Aquind Interconnector

Hampshire County Council response to Applicant's Deadline 7 submissions

Hampshire County Council's comments, as Highway Authority, on these additional technical documents are provided below. Comments on the dDCO set out in a separate document.

Plate 1 - Typical Laydown Area Dimensions [at Joint Bay locations](#)

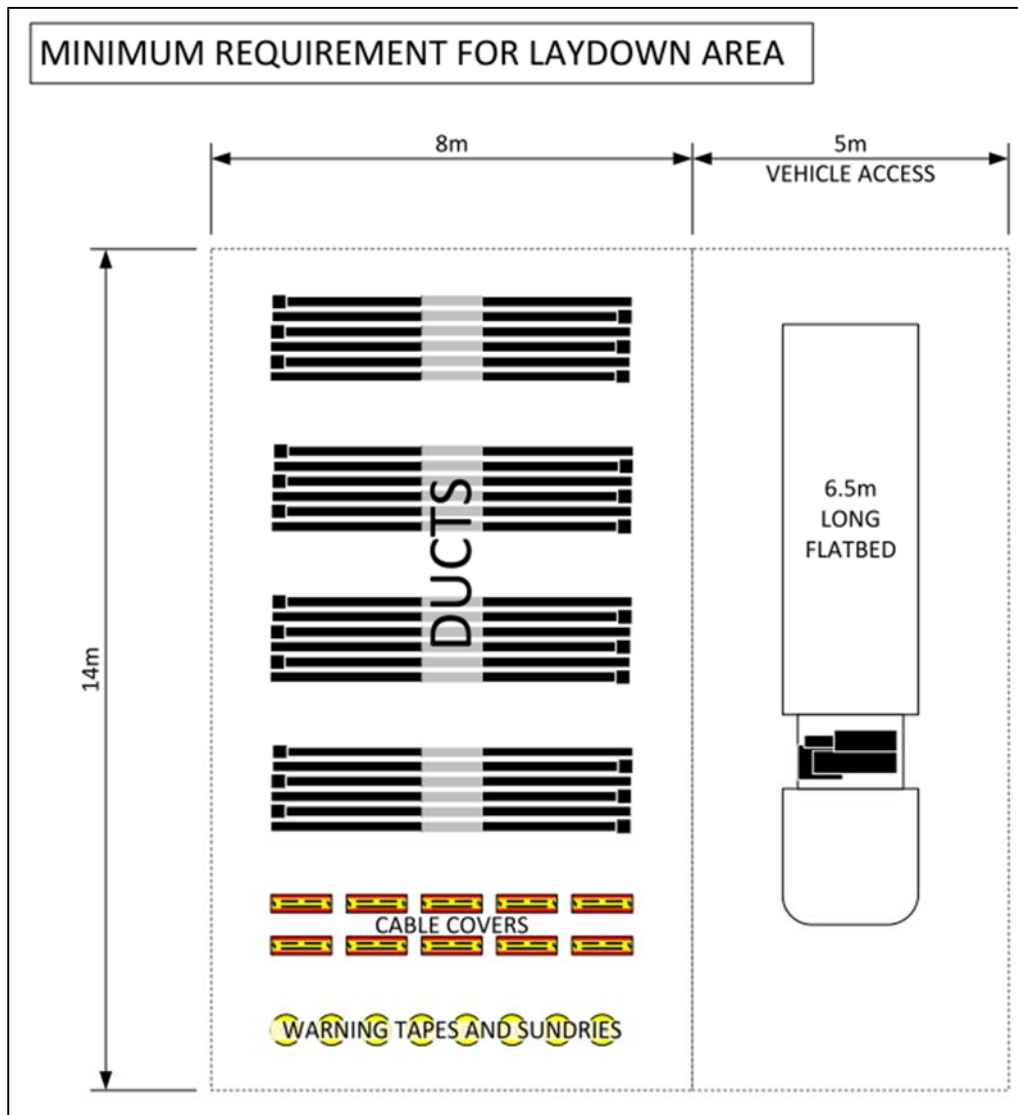
As outlined in HCC's Deadline 7 response, there remains a number of concerns over the proposed location of the suggested locations of the joint bays within HCC's network. The concerns raised in the previous response are as follows:

- Consideration of the traffic impacts during construction of the joint bays.
- Further information on joint bays 6 – 16 which are predominantly located within the highway.

An updated report has been submitted by the applicant which has considered some of the points raised at Deadline 7. The revised report confirms that access on Hambledon Road service road shall be maintained throughout construction and managed through the construction process. Primarily the Highway Authority are waiting for revised versions of the FTMS and to be satisfied that the construction of joint bays has been properly considered.

Plate 6 - Proposed construction traffic management on Day Lane - will be replaced with full page image when issued as PDF

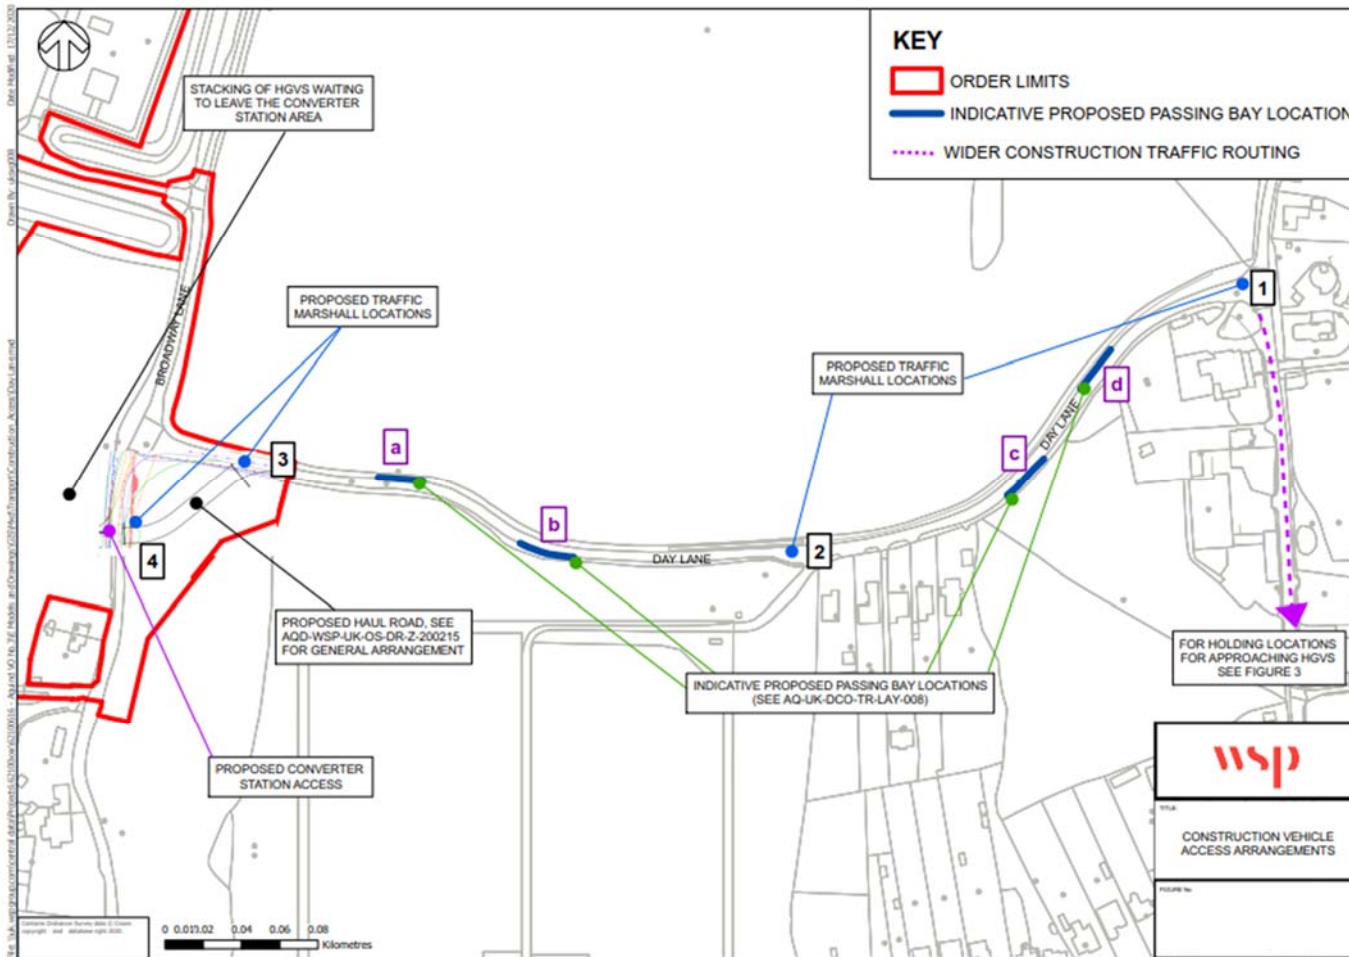
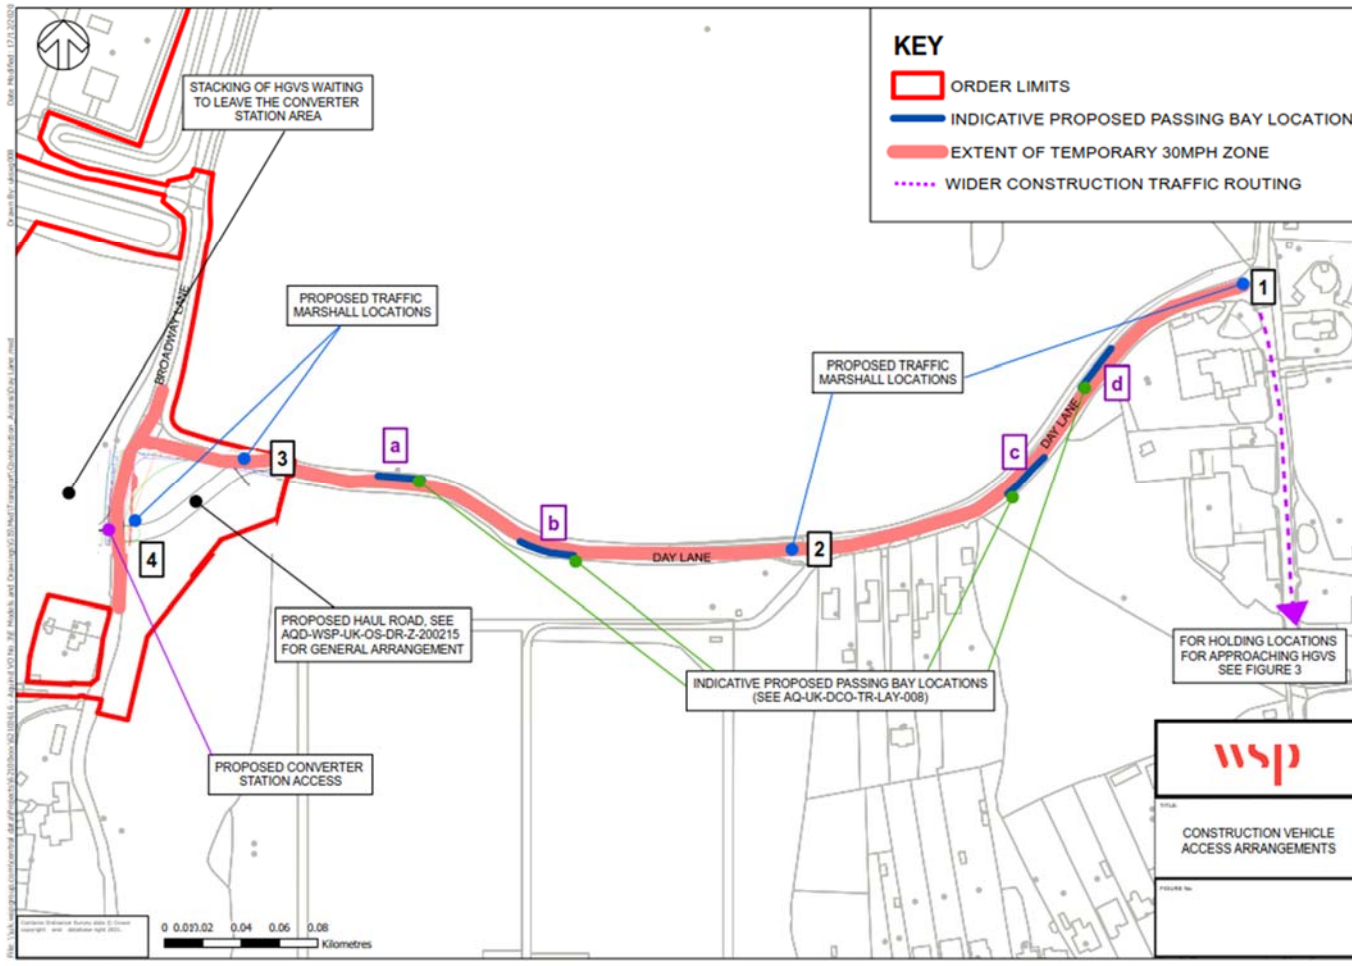
The management of HGV movements will be used in collaboration with the Day Lane banksmen/traffic marshals. STOP/GO boards will be used to hold traffic on Broadway Lane and at the Lovedean Lane junctions with Day Lane when convoys are approaching Day Lane and dedicated passing places (shown in drawing number AQ-UK-DCO-TR-LAY-008 Rev B) will give flexibility should it be required for a vehicle to be able to wait for the convoy to pass.

Whilst the principle of this strategy is now considered acceptable, there are a few points that the applicant has yet to address:

1. Implementation of a TTRO which reduces the speed limit on Day Lane to 30mph from Lovedean Lane to Broadway Lane south of the site access. The TTRO will be required for the life of the project.
2. Provision of the engineering details requested in HCC's D7 response in relation to the Day Lane passing bays.
3. Resolution to concerns relating the enforcement of the parking suspension requirements, in particular at Hulbert Road layby.
4. Commitment in the DCO to restrict the maximum number of HGV movements to the converter station as set out within Page 2 of the latest Day Lane Construction Management Strategy note. The report currently refers to the management of "project related" construction HGVs from meeting each other on Day Lane but actually the system prevents any "project related" HGVs meeting any other HGV traffic along the lane. This should be reflected within the note.

5. The report proposes that the management system is only in place during peak construction. This is not as agreed. The management system needs to be in place to manage all HGV movements to the site from the commencement of construction, hence the requirement for the site access works and Day Lane works to be implemented prior to commencement and the Day Lane operation to manage HGV movements to be in place.

6. The management of HGVs arriving to the converter station for the construction of the onshore cable route should also be subject to the same arrival process. The HGVs should be released in groups no more than 3 times in an hour to reduce the delays to other users of Day Lane during construction. This should be reflected within the note.

7. A note should be included which states that HGV movements will be controlled at a maximum of 15mph while travelling along Day Lane to provide the appropriate time to react to any traffic travelling in the opposite direction to the convoy.

The Highway Authority have had sight of the applicant's revised submission of the final Day Lane technical note which is to be submitted at Deadline 7C. This has appropriately addressed all points above, except from numbers 3 and 4. As already set out, the matter of enforcement of parking restrictions or suspensions is outstanding and the control on HGV movements is not provided for within this technical note or the DCO.
